Ribble Valley Borough Council  
Housing & Development Control

Application no: **3/2023/0305**

Address: **Land at former Higher Standen Farm (adj Swardean Way Valley Lane Higher Peak Crescent South Gate Broadfield Street) Pendle Road Clitheroe BB7 1PR**

Proposal: **Proposed construction of a 68 bed residential care home, related infrastructure and landscaping.**

DRAWING TITLE
Proposed Ground Floor GA Plan

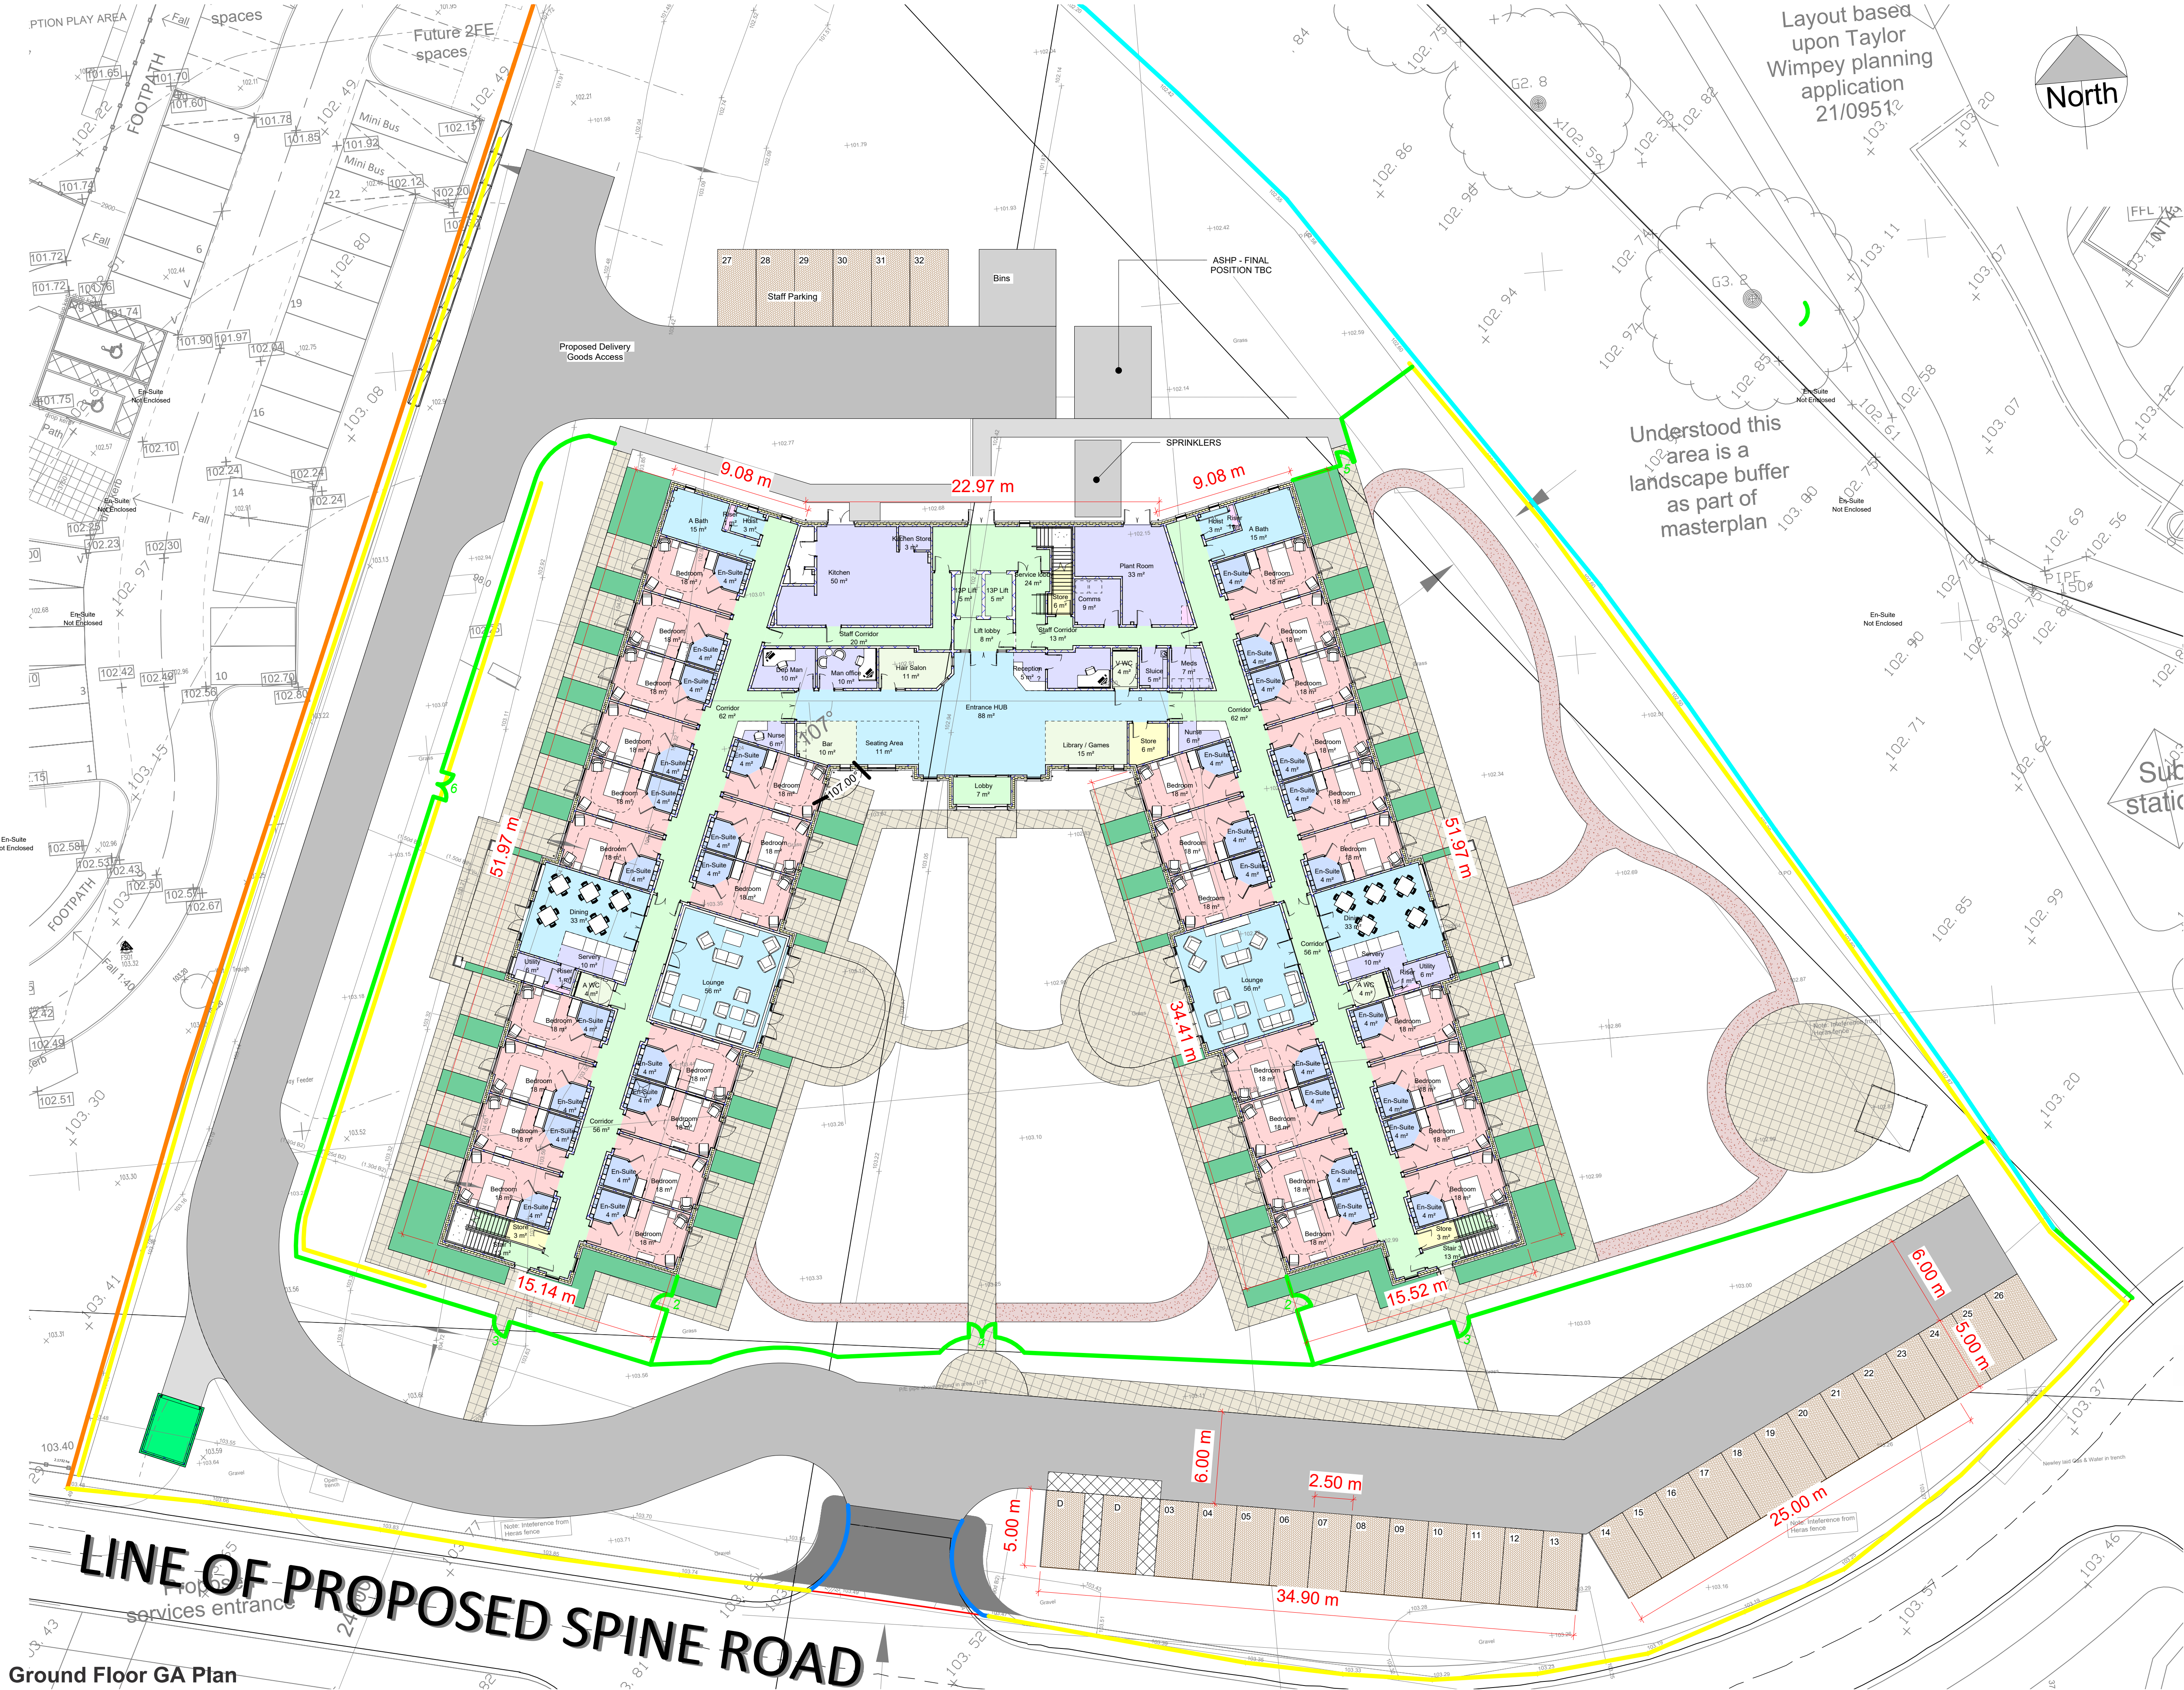
The LHA have reviewed DWA drawing number 101 Rev D titled "Proposed Ground Floor GA Plan," and require a swept path drawing of a refuse vehicle using the internal carriageway which will serve the servicing area. This is to ensure that the width of the internal carriageway is adequate, and that the turning area provided can be used by large, refuse vehicles.

The LHA will also request that the 2m wide footways provided on both sides of the site access are extended further into the site. The LHA will request that the footway to the left of the site access is extended until it is directly opposite the internal footway which serves the care home, on the opposite side of the carriageway. While the LHA will request the footway to the right of the access and the internal footway serving the care home, are extended until they are opposite one another. This is to ensure that there are segregated footways for pedestrians to use, with the footways currently terminating without any connections.

The LHA have reviewed DWA drawing number 101 Rev D titled "Proposed Ground Floor GA Plan," and are aware that the site will provide 32 car parking spaces to serve the site. This complies with the LHAs parking guidance as defined in the Joint Lancashire Structure Plan, given the number of residents at the proposed 68 bed care home.

The LHA will request that 3 of these spaces are designated accessible bays and a further 3 spaces have access to electric vehicle charging points. The LHA will also request that cycle storage facilities are provided.

The LHA require a swept path drawing of a large refuse vehicle using the internal carriageway serving the provided turning and servicing area and the footways located at the site access, should be extended internally to connect to the footway serving the care home on the opposite side of the internal carriageway. This should be shown on an amended plan submitted to the LHA.

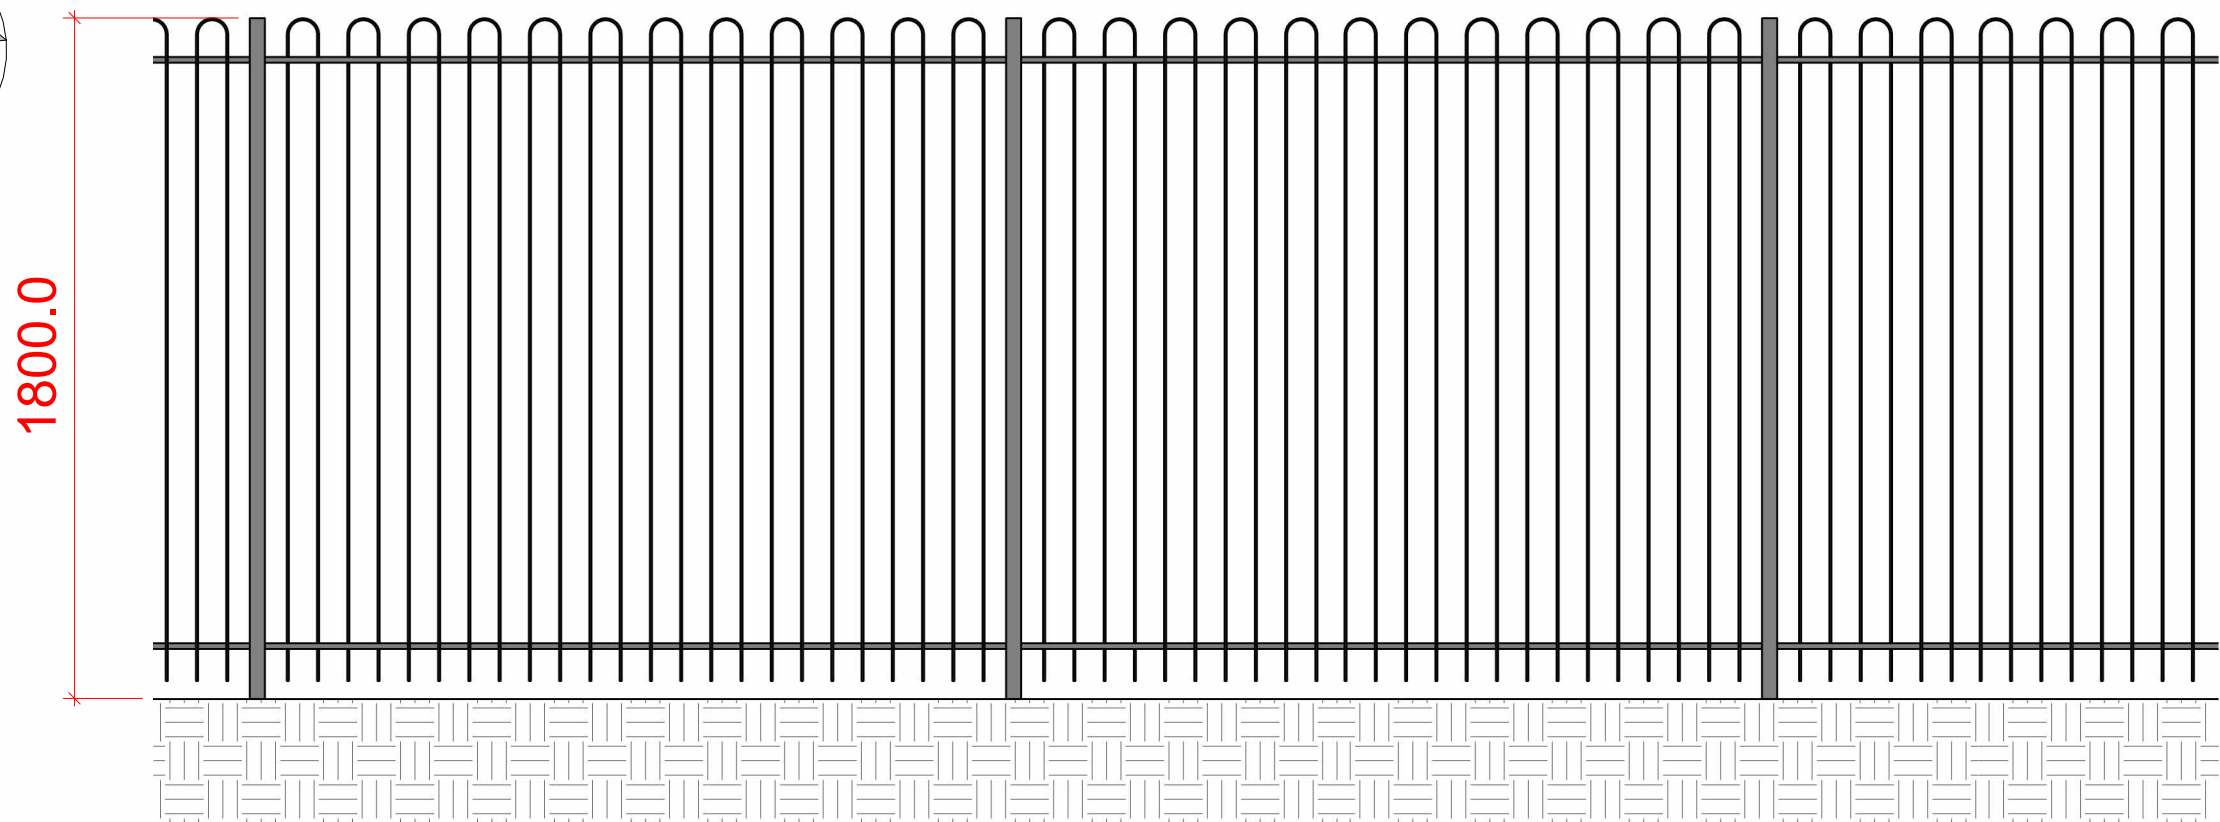
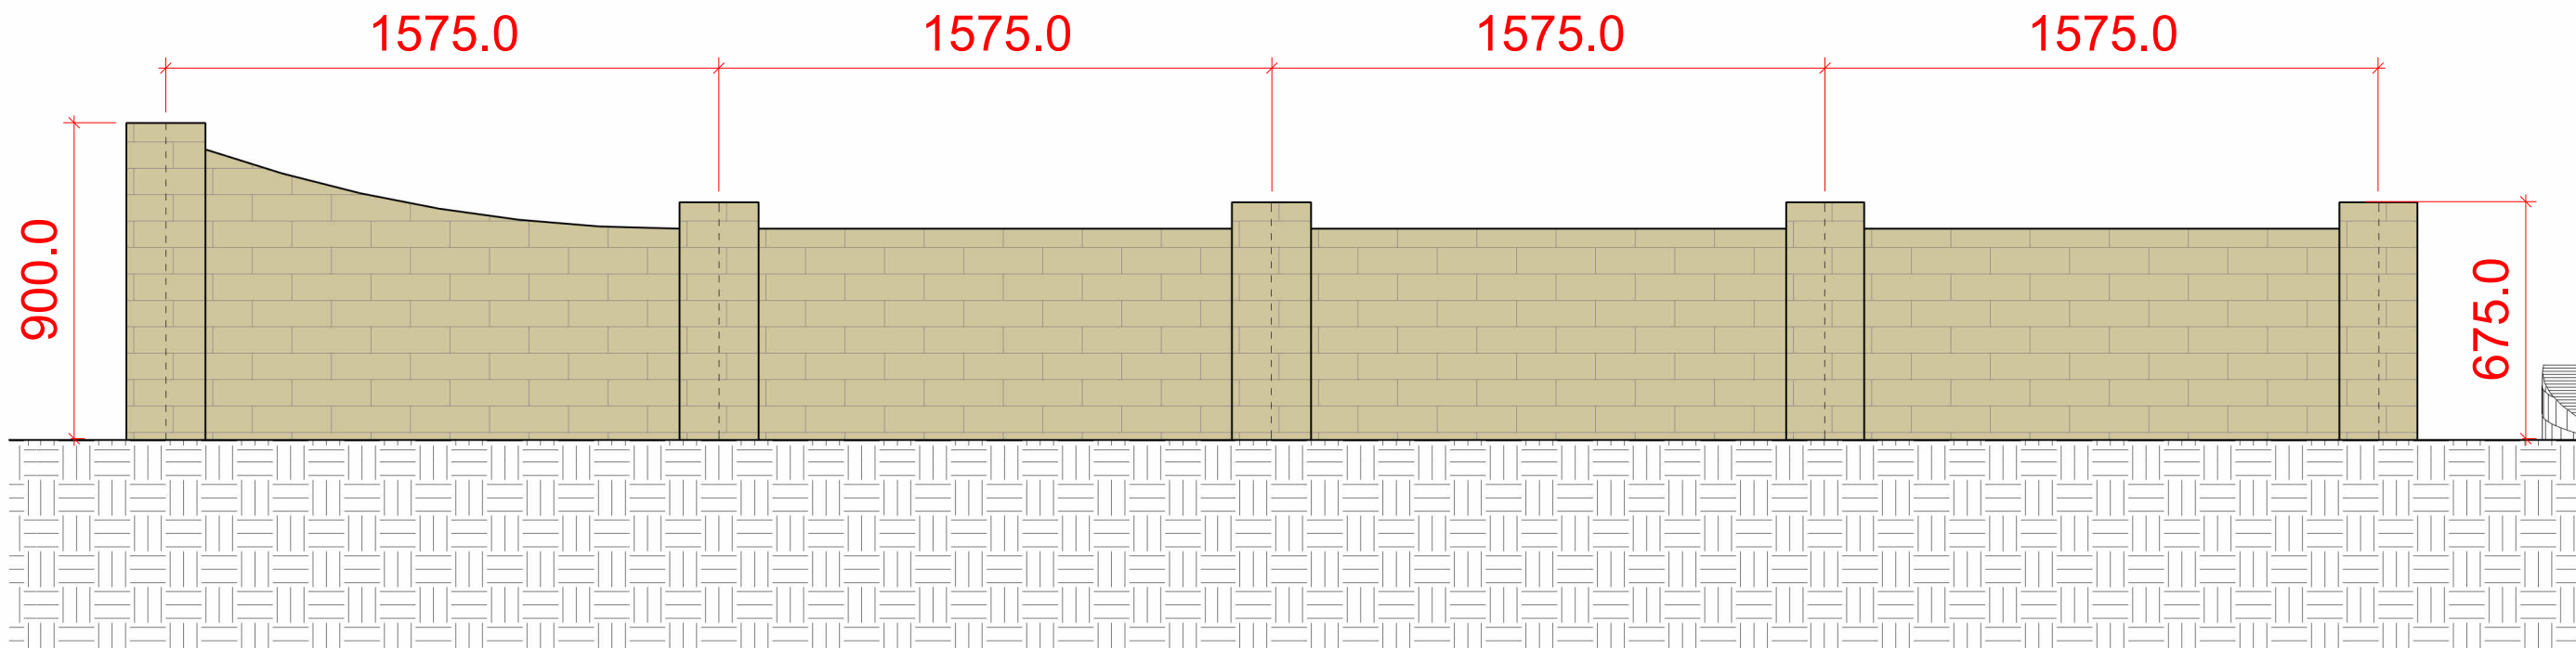
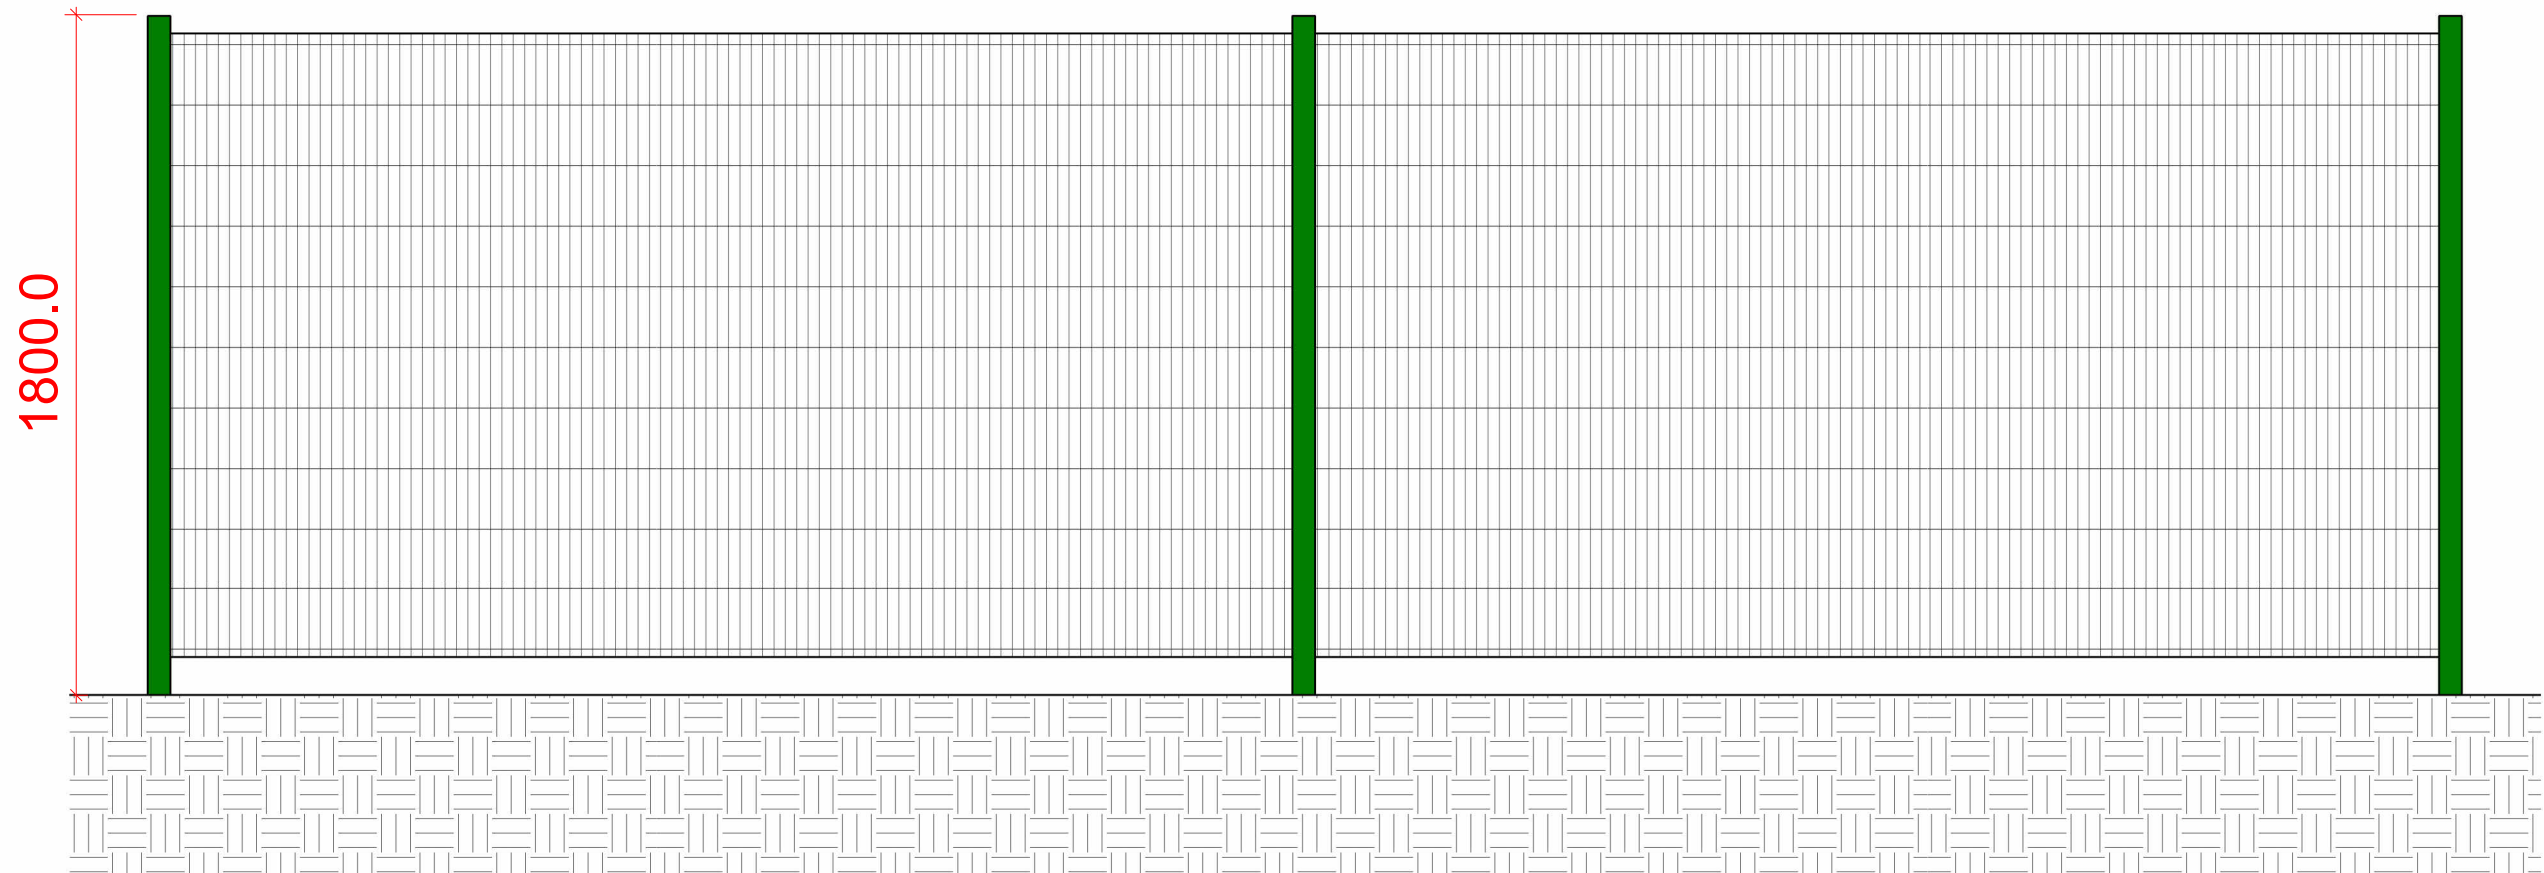
However, the LHA have reviewed DWA drawing number 194 Rev E titled "Proposed Boundary Treatment Plan," and require details regarding the height of the hedge, which is likely to be located in the access's visibility splays. The LHA remind the Agent that the hedge will need to be no higher than 1m to ensure that it will not obstruct the sites visibility splays.
